**WEST SUSSEX COUNTY COUNCIL
STRATEGIC PLANNING CONSULTATION**

SUBJECT: A/94/15/PL

**Change Of Use from C3 (Dwellinghouses) to D1 (Non- residential institutions)
to accomodate a new timber framed Nursery / Pre School, together with
replacement stabling and detached 3 bay garage.**

Brackenside, Dappers Lane, Angmering, West Sussex, BN16 4EN

Existing vehicle access point

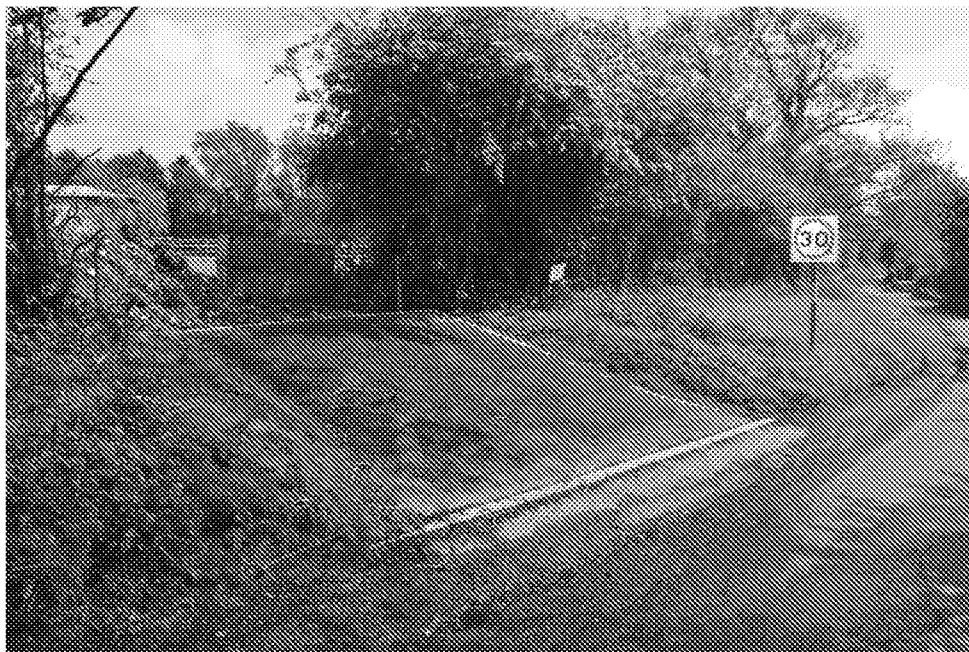
Site access is proposed via the construction of a new access onto Dappers Lane. Little information has been provided other than the site access being constructed to a width of 4.5m.

It is unclear whether the access is fit for the intended purpose. The location of the access is within the derestricted section of Dappers Lane and whilst speeds are unlikely to be in the region of 60mph given the narrow and winding nature of Dappers Lane at this point, it has not been demonstrated that adequate visibility can be achieved in accordance with the average speeds. Similarly, no tracking has been provided to demonstrate that vehicles can manoeuvre and pass other vehicles at the point of access. The site access has not been subject to a Stage 1: Road Safety Audit.

- (i) It has not been satisfactorily demonstrated that the proposed new access to the site from Dappers Lane does not have a detrimental impact on the safety of highway users and that it is suitable for its intended use
- (ii) Dappers Lane, from the change in speed limit approximately 150m to the south of the site and continuing north, is unsatisfactory to serve the proposed development by reason of its inadequate width and forward visibility, and the proposal would be likely to generate additional traffic that would lead to conditions detrimental to highway safety
